**Subject:** Proposed cottage and stables at Kitchens Farm, Application 3/2011/0497

The proposed erection of a holiday cottage and stable at Kitchens Farm has, in landscape terms, a fundamental flaw; location of the new buildings away from the existing farm complex. This approach would inevitably result in localised landscape character impacts, a loss of open space, landscape fabric losses and a greater degree of visual intrusion in the AONB landscape than if the proposed buildings were located within the Kitchen Farm complex. It is worth noting that since the applicant has no proposals for compensating for landscape fabric losses an overall net loss of landscape resources would occur which is contrary to RSS policy.

Client's Details,
Mr & Mrs. A. Tootle
Project Details,
Existing Site Plan
Tree Survey
Project Address,
Kitchens Farm
Bashall Eaves
Clitheroe

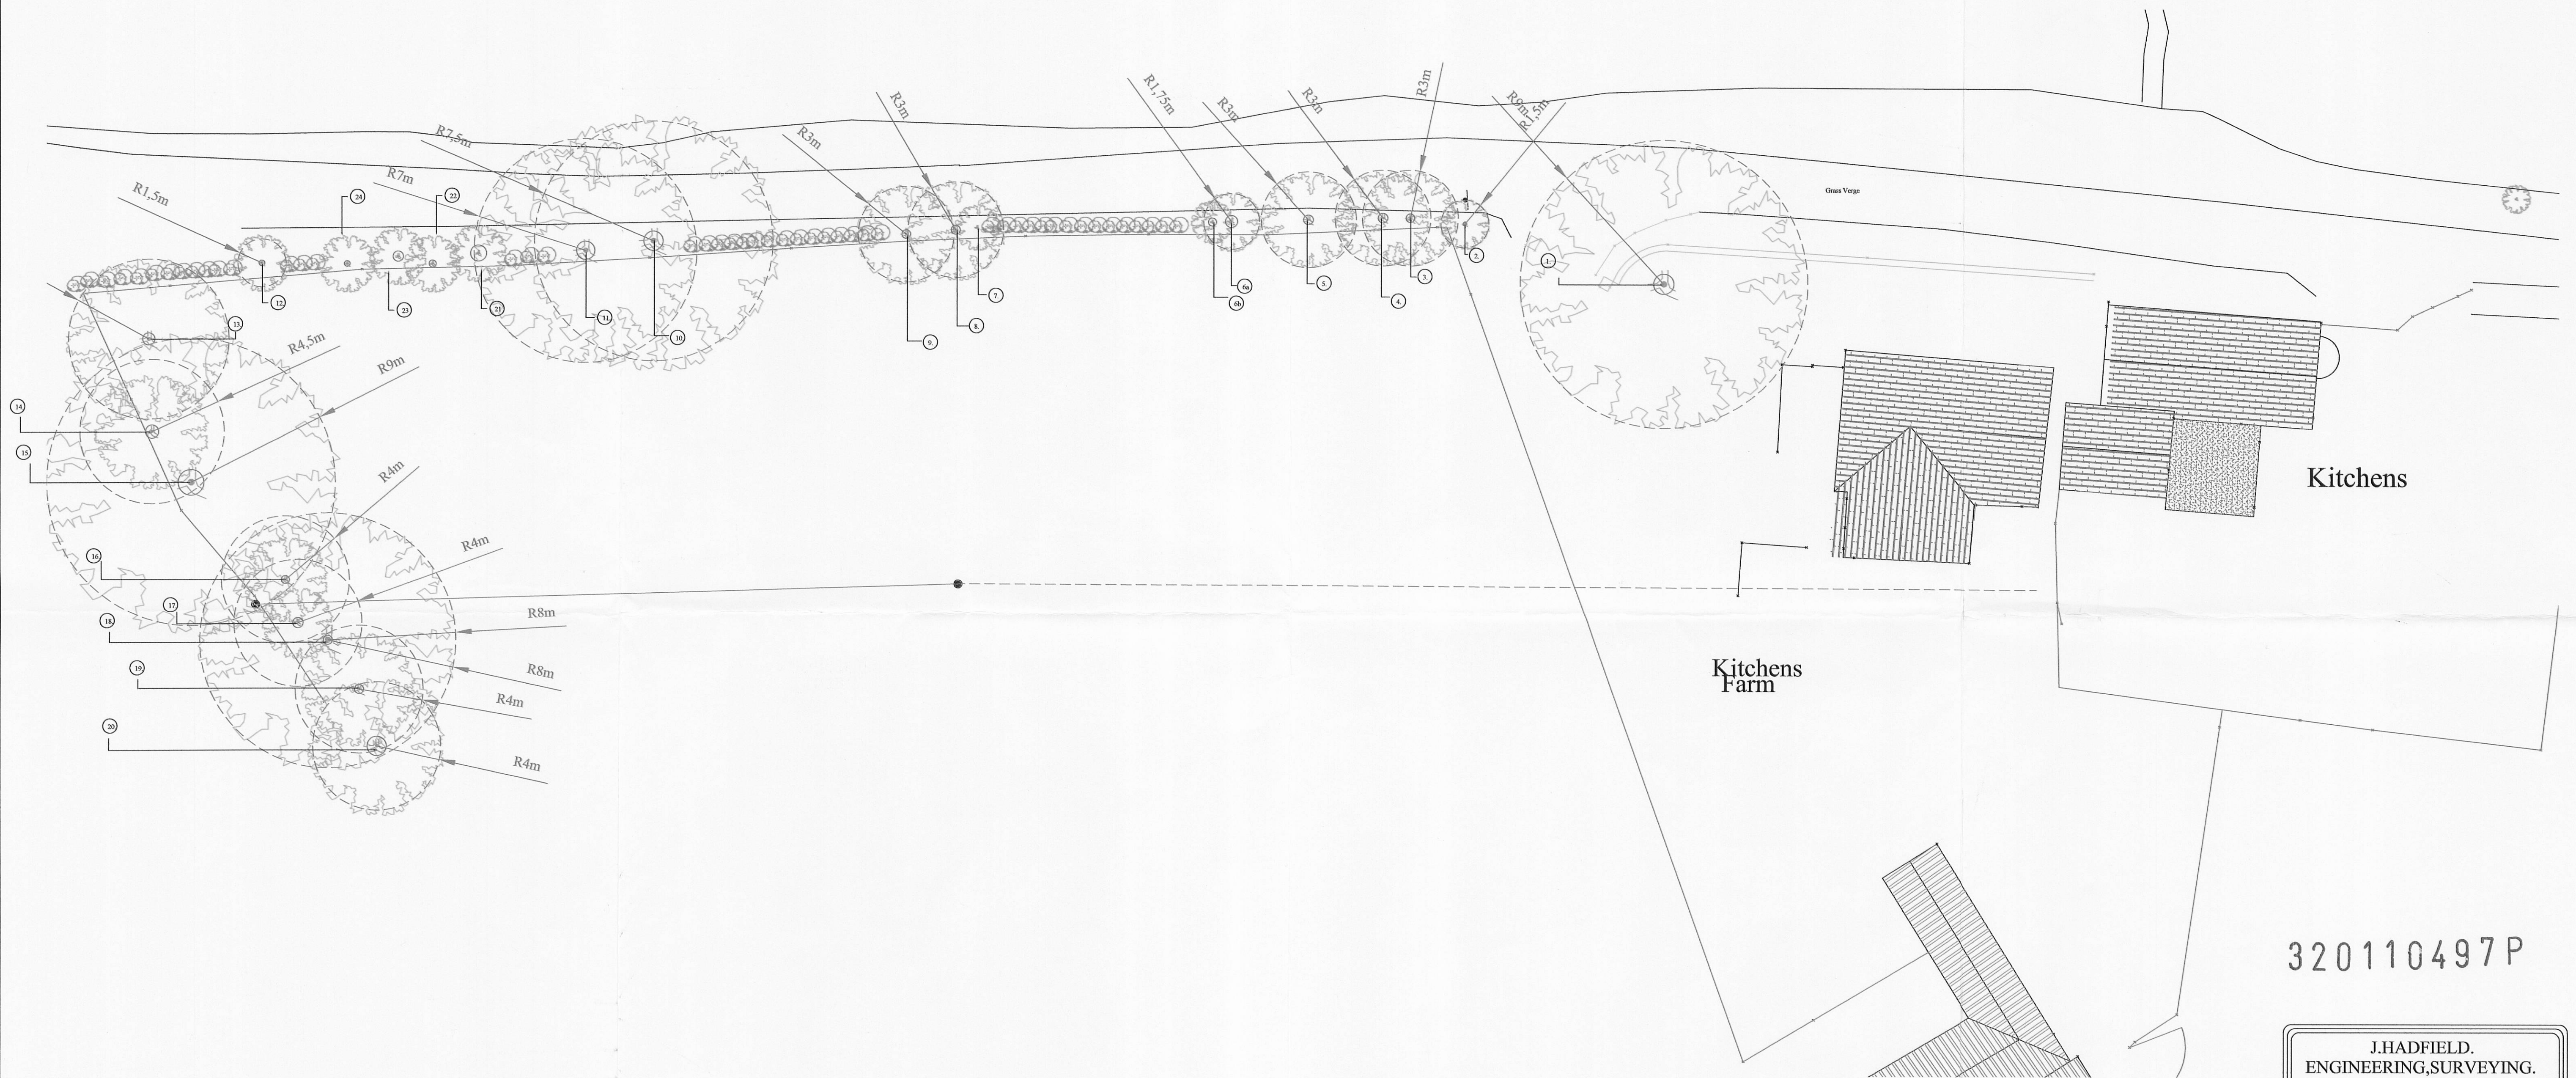
An analysis of the landscape's sensitivity suggests that there is some capacity for additional built development of the type proposed. However successful mitigation of landscape and visual impacts would depend upon good design and a strong functional/visual relation being established between existing and new development. As outlined above, the proposed scheme does not satisfy this latter requirement.

For the reasons outlined above, I recommend that the applicant explores other development options which involve relocating the proposed buildings within the Kitchen Farm complex.
